**KIRKLEES METROPOLITAN COUNCIL
INVESTMENT & REGENERATION SERVICE**

**DELEGATED DECISION TO DETERMINE APPLICATIONS FOR
CONSENT, AGREEMENT OR APPROVAL REQUIRED BY CONDITION**

Reference No:	2023/44/92935/E
Site Address:	27A-33, Commercial Street, Batley, WF17 5EP
Description:	Discharge of condition 6 (kitchen extraction) and 7 (prevention scheme) on previous permission 2020/94331 for change of use of retail unit to restaurant and alterations including balcony
Recommending Officer:	Elenya Jackson

**DECISION – SPLIT DECISION - DISCHARGE OF CONDITION 7
APPROVED**

title      Extraction flue component schematic

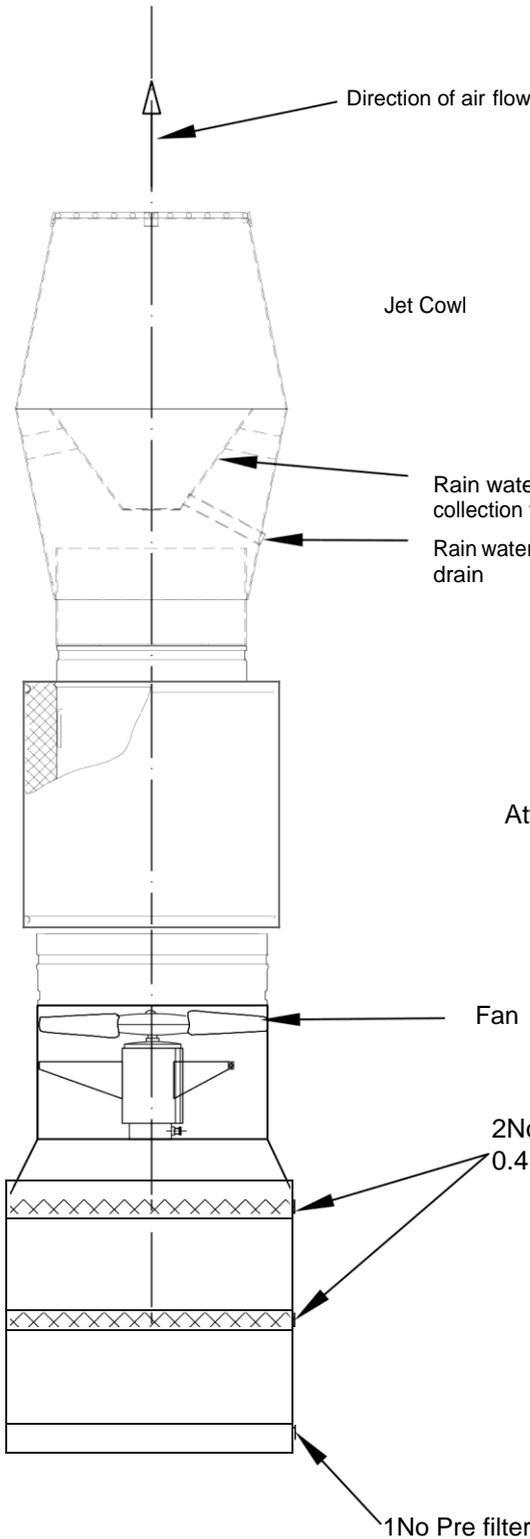
'The risk assessment correctly identifies the need for a very high level of odour control at the premises and goes on to specify the necessary components that should be built into the extract system to achieve said odour control. We are concerned that the extract ventilation statement goes on to contradict the risk assessment in that it does not include all the required components of the extract system and offers a lower standard of odour control. The extract ventilation statement does not specify the exact height above the eaves of the terminus of the flue to the system, we require this in diagrammatic form.

Due to inconsistencies in the documents, we do not accept the information provided and make the following recommendation'.

Therefore, the details provided for the discharge of condition 6 are not considered acceptable and the condition cannot be discharged at this time.
